Application for a Non-Material Amendment Following a Grant of Planning Permission

Three storey rear extension, single storey attached garage to the side, new roof and attic conversion with dormers to front elevation.

: 22/00749/FUL

Increasing the size of the rear extension. At ground floor we are proposing to take the rear elevation out by 1m further than originally consented.

CLIENT Mr & Mrs Simpson		PROJECT NO. 370		DRAWING NO. AP011		REVISION D	
PROJECT No.1 Shire Mill Close, Mossley		DATE OF DESIGN 08.07.22		SCALE 1:100 @ A3		DRAWING TITLE Proposed Attic Floor Plan & Roof Plan

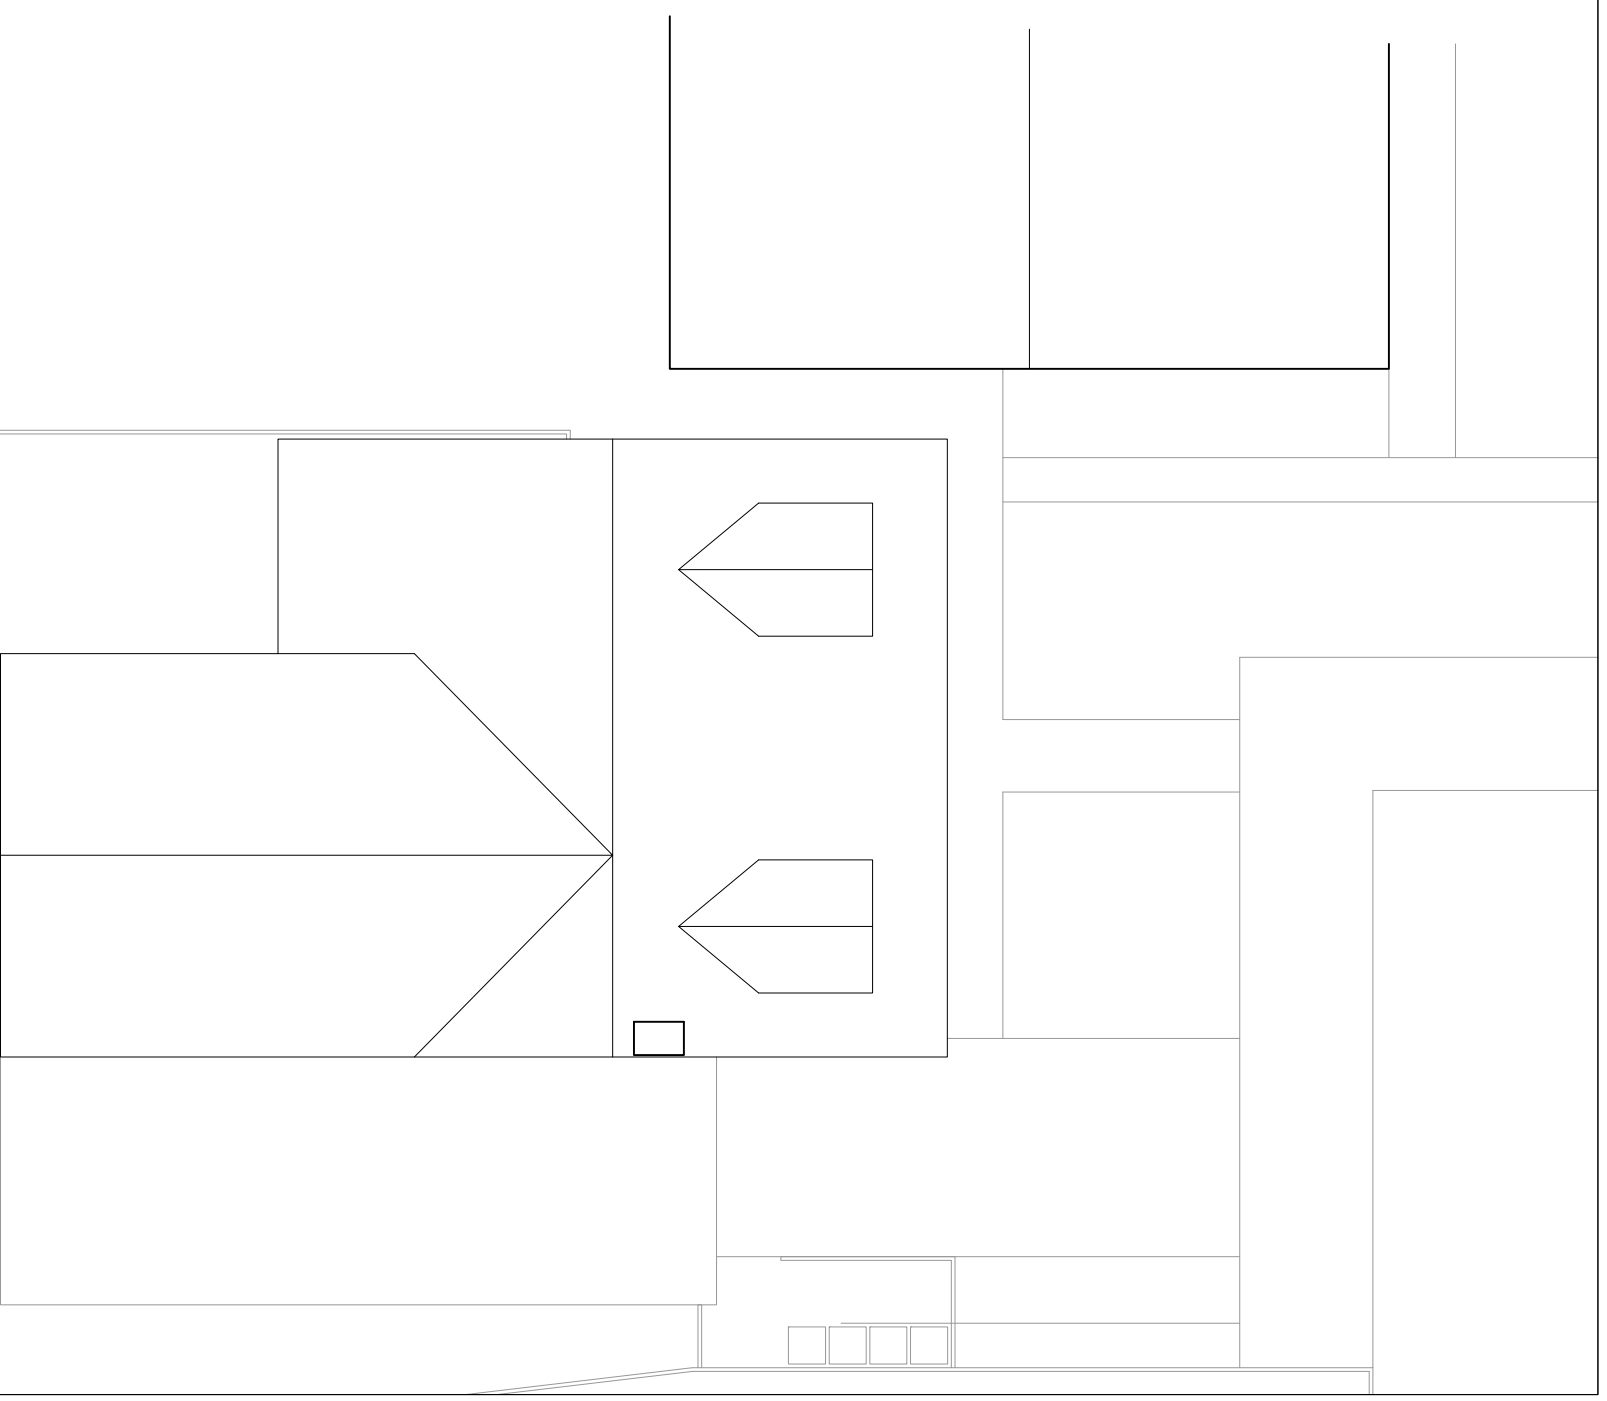
This increase in size is then repeated only for the 3 storey element to the rear. At first floor bedroom 3 will increase by 1m but bedroom 2 remains unchanged. The master bedroom at the attic level will also extend out to the rear a further meter in line with the first floor.

370 AP011 D Proposed Attic & Roof Plan

DRAWING TITLE Proposed Ground & First Floor Plans

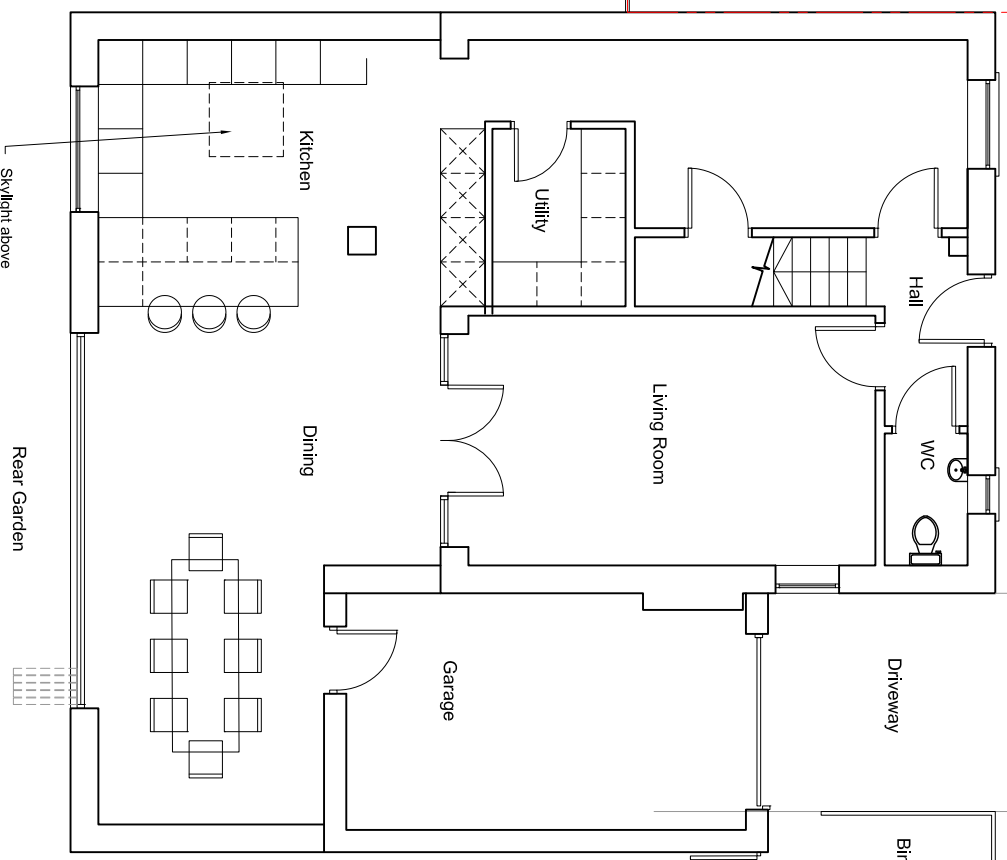
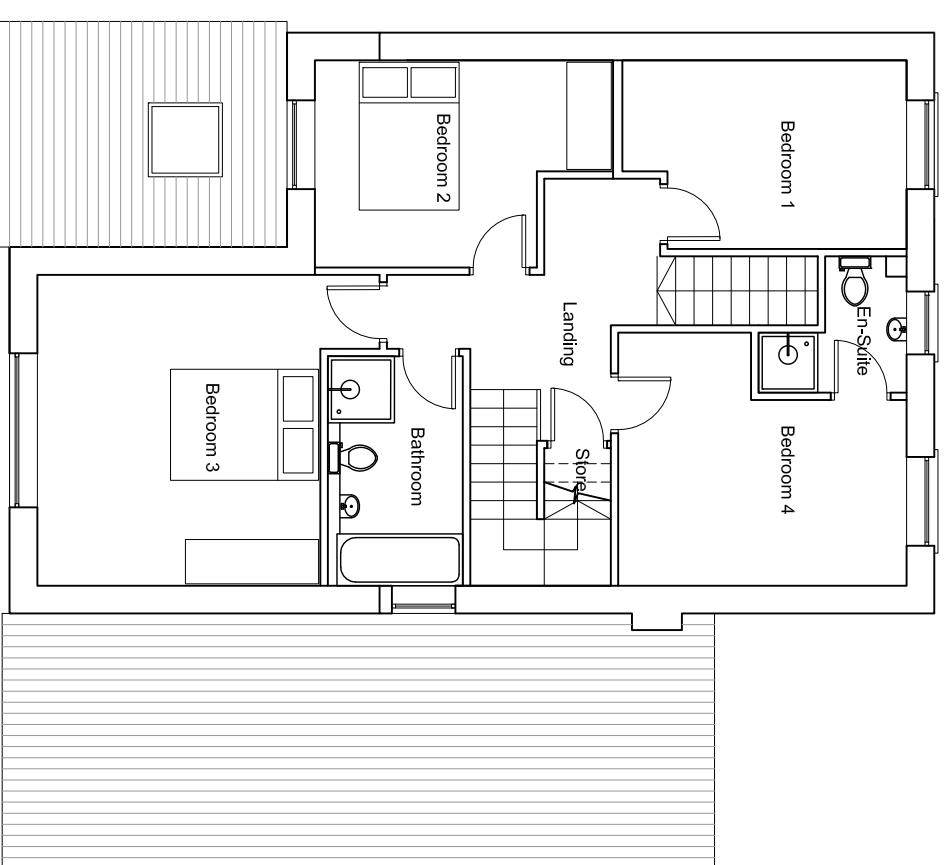
370 AP010 D Proposed Ground & First Floor Plans

DATE	07.02.24	DESCRIPTION	D	REVISION	D
General amendments					
CLIENT	Mr & Mrs Simpson				
PROJECT	No.1 Shire Mill Close, Mossley				
DRAWING TITLE	Proposed Elevations				
SCALE	1:100 @ A3	DATE OF DESIGN	08.07.22	PROJECT No.	370
				DRAWING No.	AP012

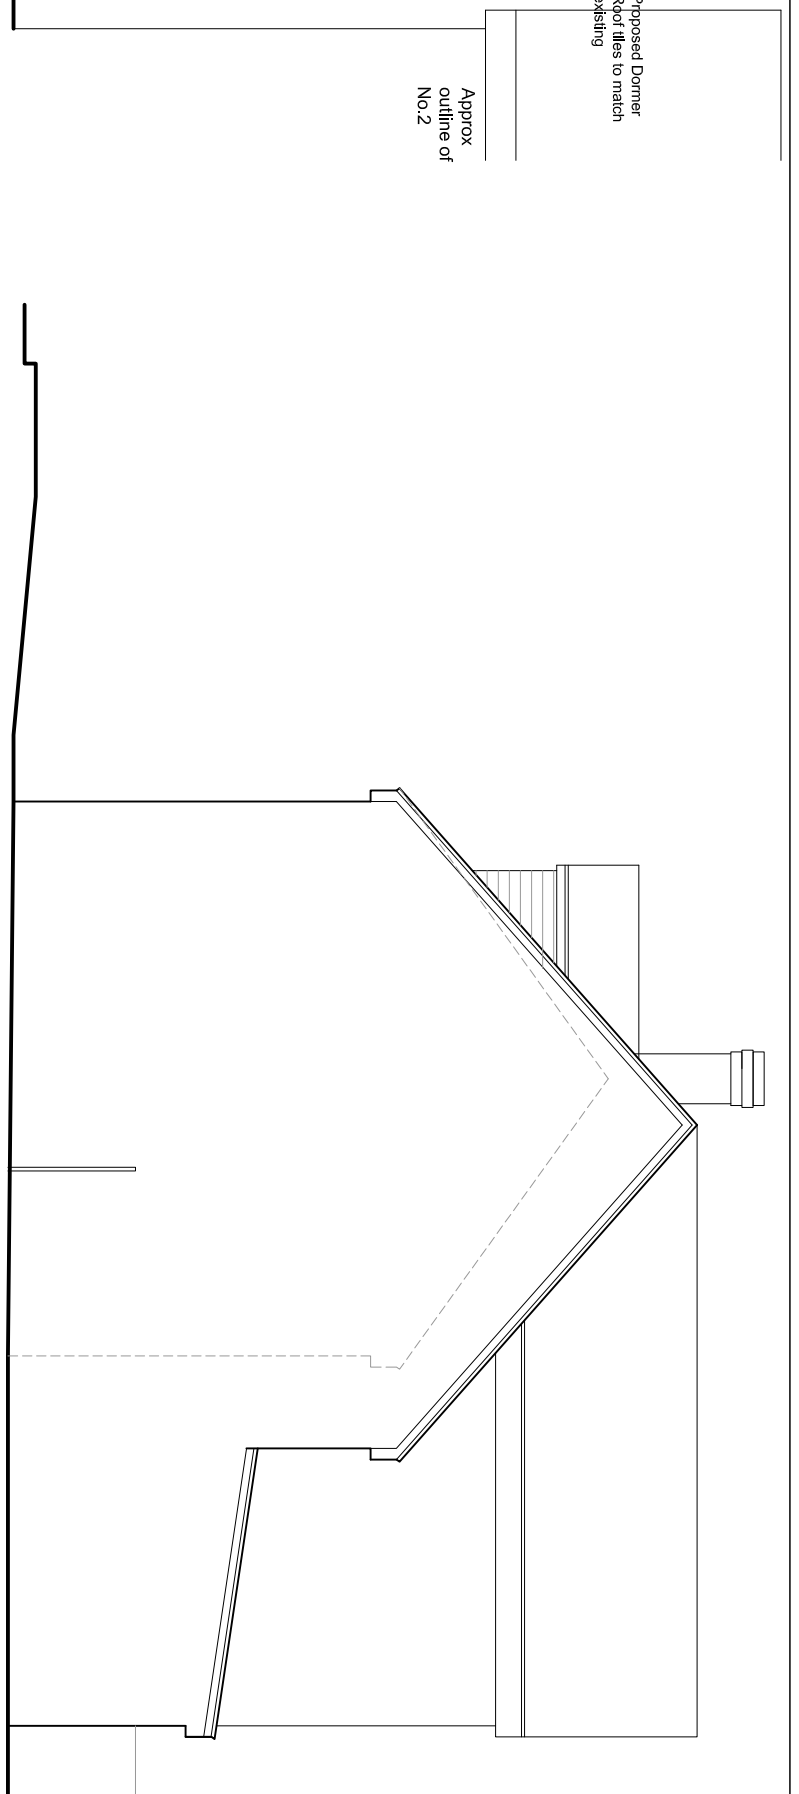
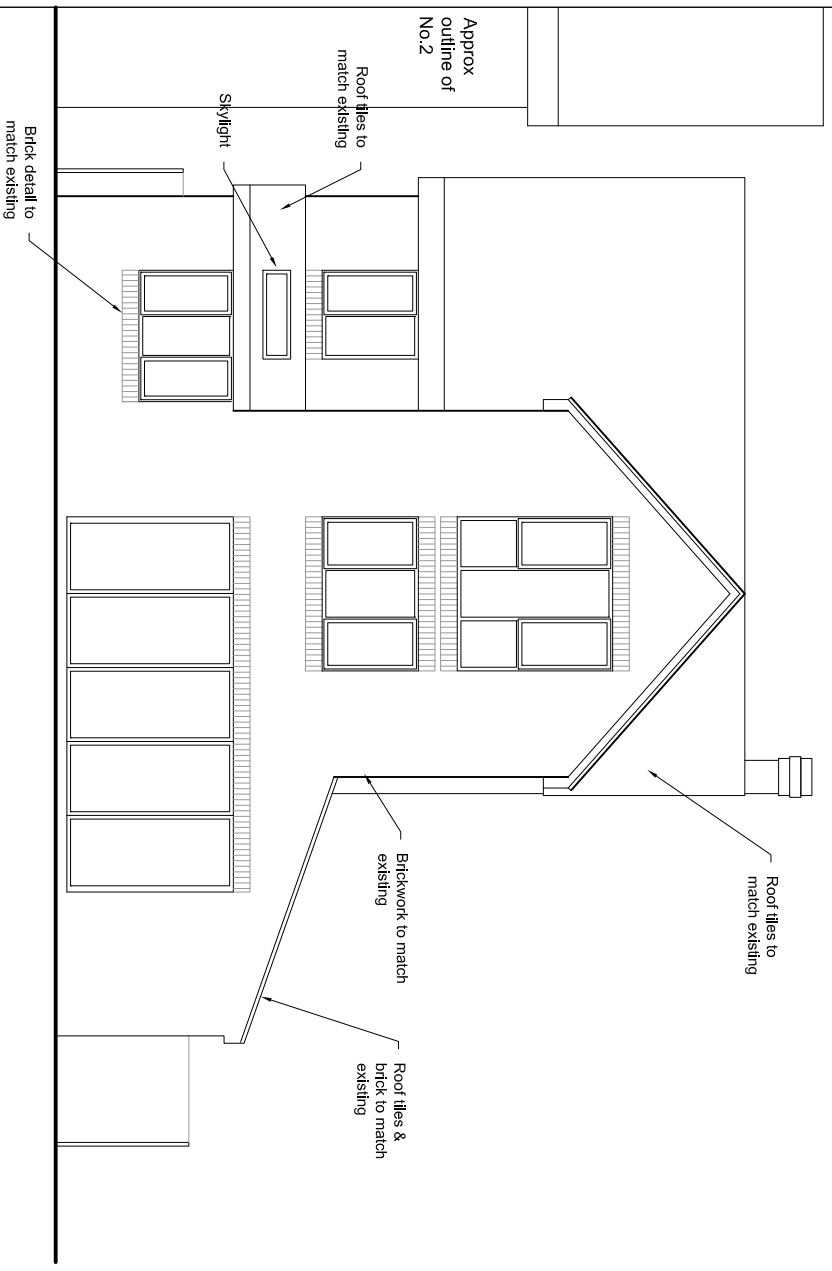
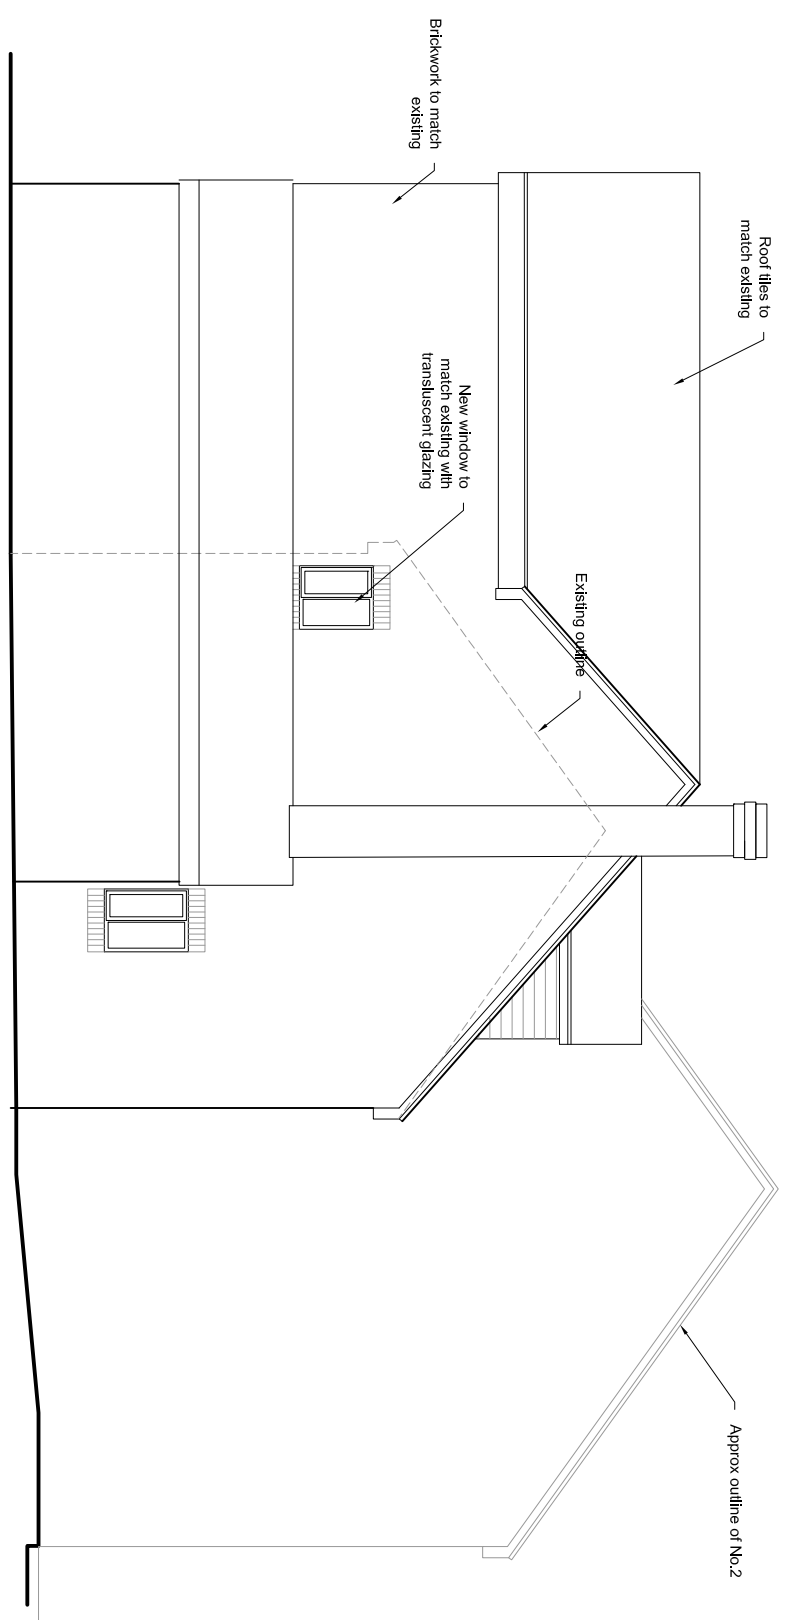
370 AP012 D Proposed Elevations
